**KITTITAS COUNTY**  
**DEPARTMENT OF PUBLIC WORKS**

**MEMORANDUM**

TO: Jeff Watson, Community Development Services  
FROM: Christina Wollman, Planner II *CW*  
DATE: July 14, 2010  
SUBJECT: Magana Short Plat SP-10-00004

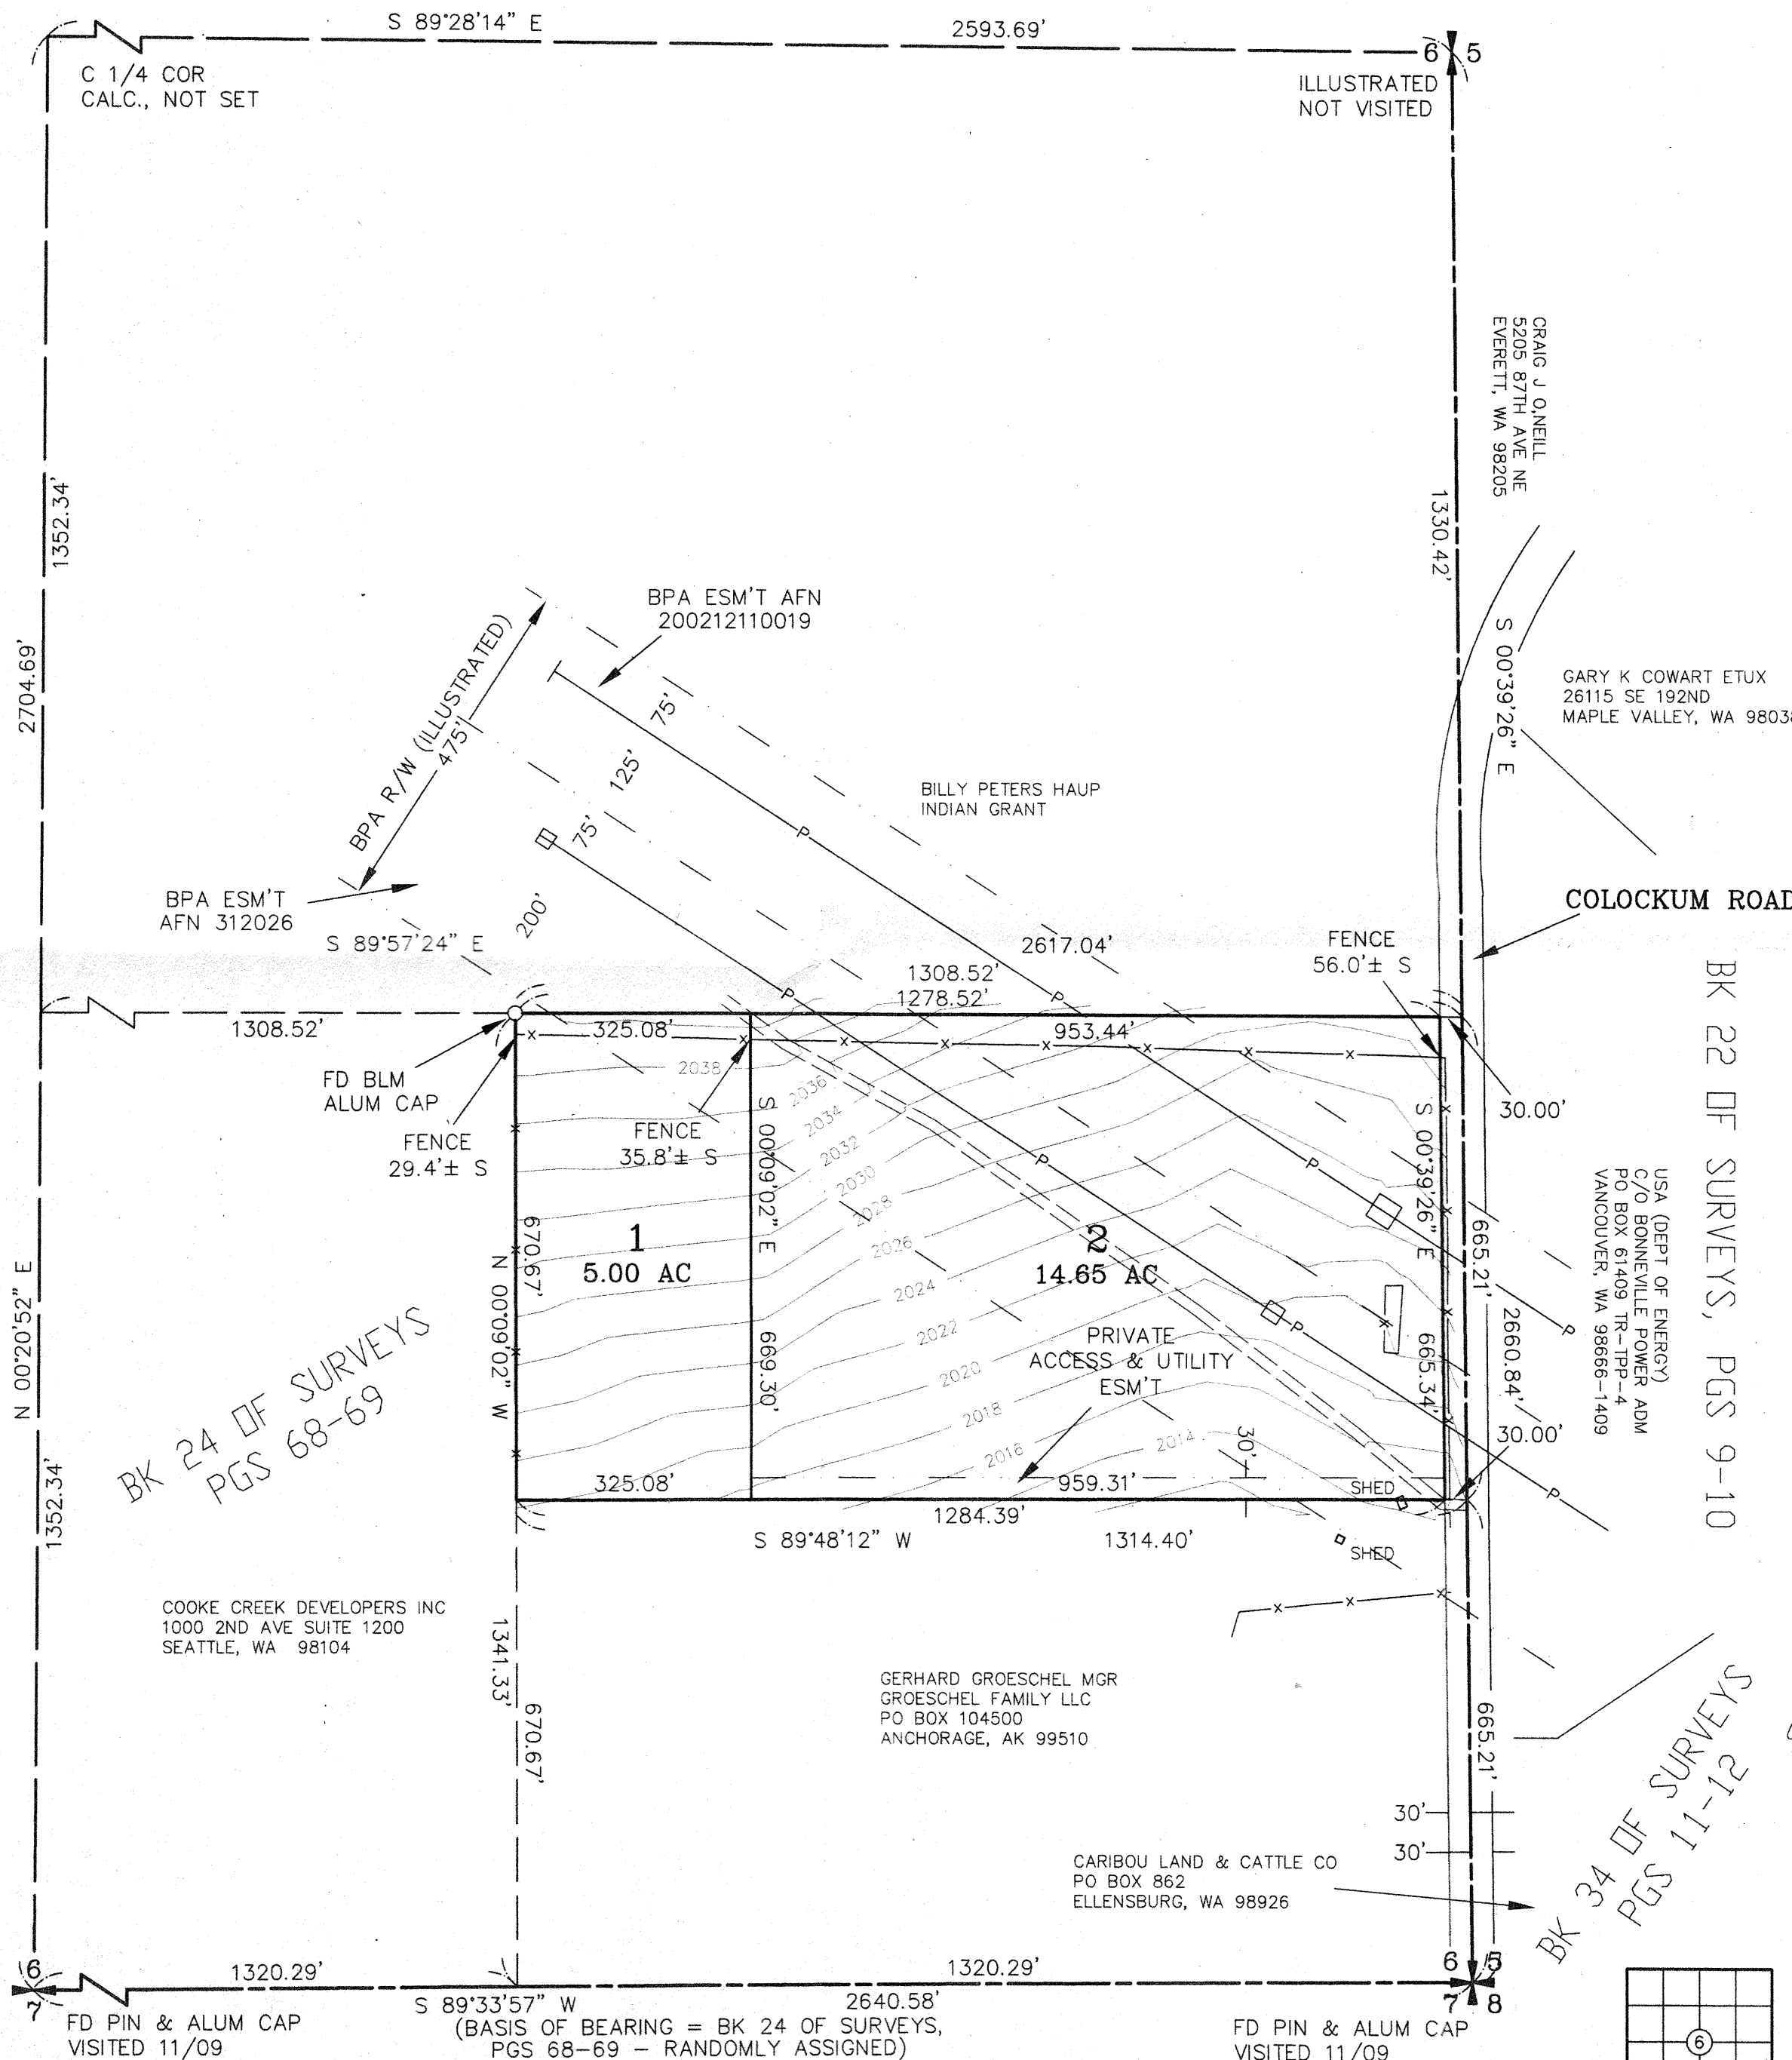
1. Joint-Use Driveway: A joint-use access shall serve no more than two tax parcels. See Kittitas County Road Standards, 9/6/05 edition.
  - a. Access easements shall be a minimum of 20' wide. The roadway width shall have a minimum width of 12'.

- b. The surface requirement is for a minimum gravel surface depth of 6".
  - c. Maintenance of driveway approaches shall be the responsibility of the owner whose property they serve. The County will not maintain accesses.
